## Fire Marshal Division

**RE: Carlie C's IGA Addition**  
**333 N. Raleigh St.**  
**Angier, NC 27501**

**Re: Application Number – FMFW1911-0004**

**LIFE SAFETY PLAN**

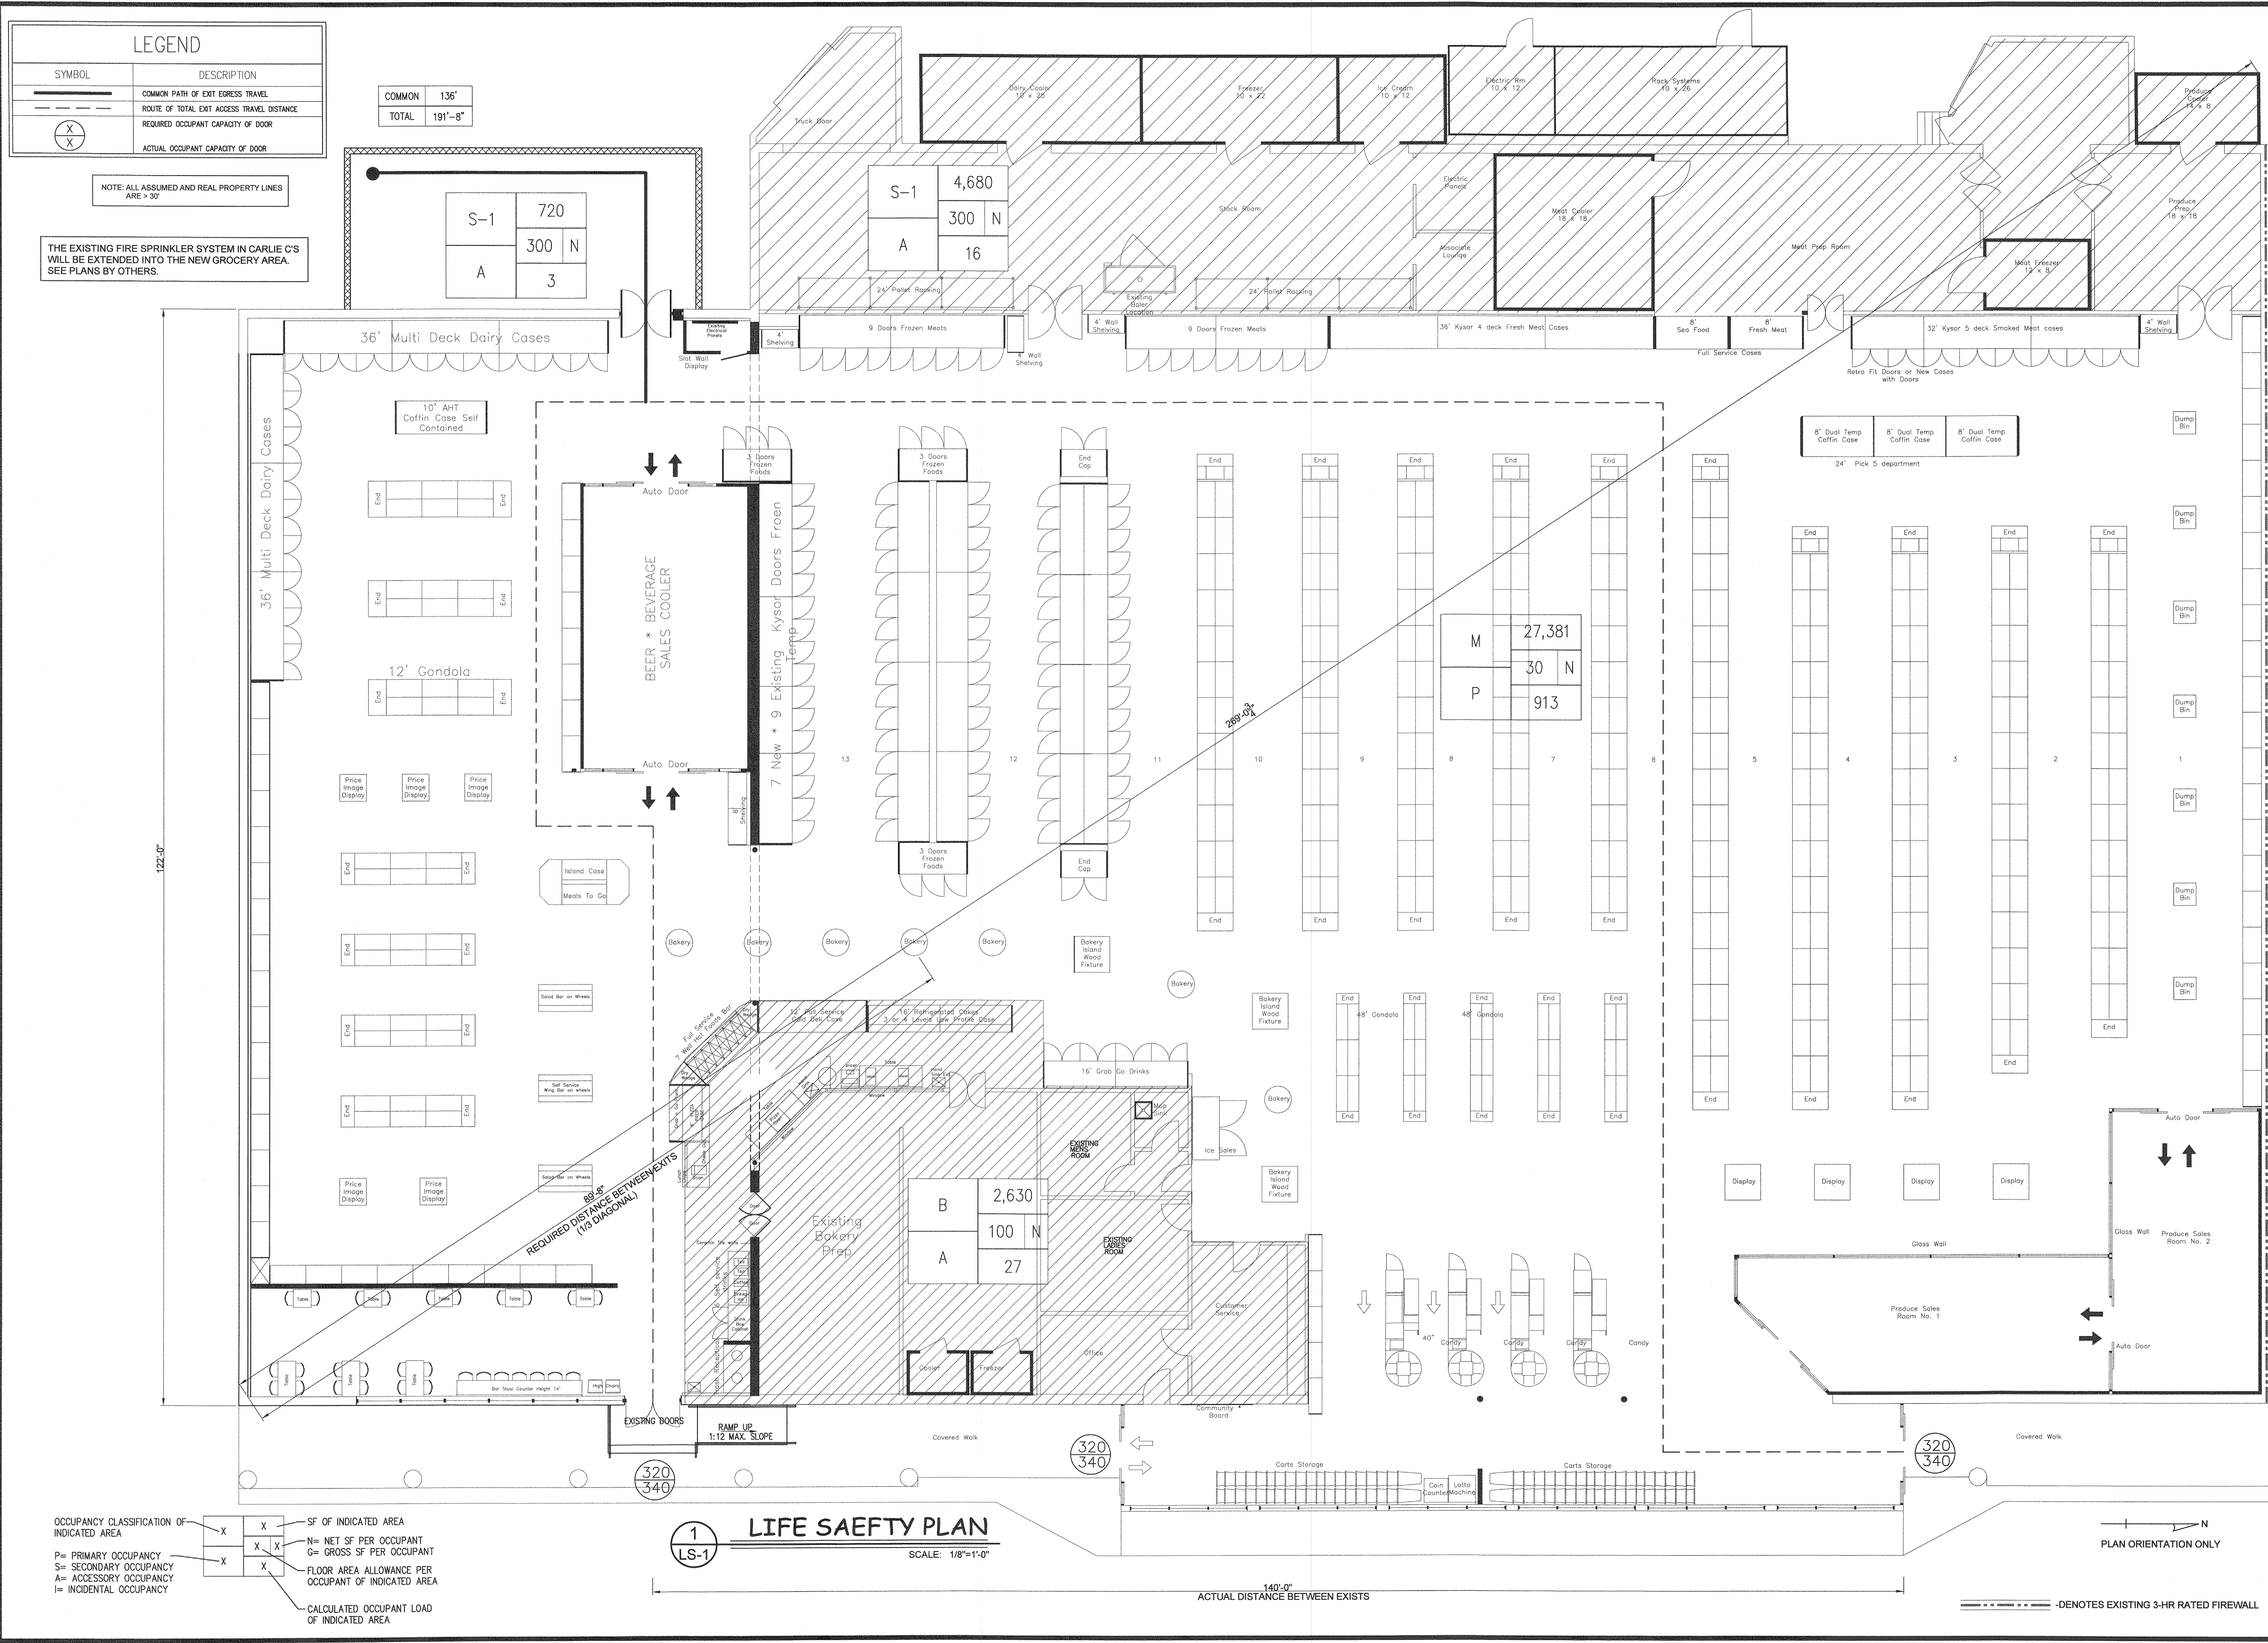
- **Notes**
  - Please clarify why the 1/3 diagonal distance for a remote exit has not been met.
  - Please note a manual fire alarm system is required by section 907.2.7 of the NC Fire Prevention Code 2018 edition.
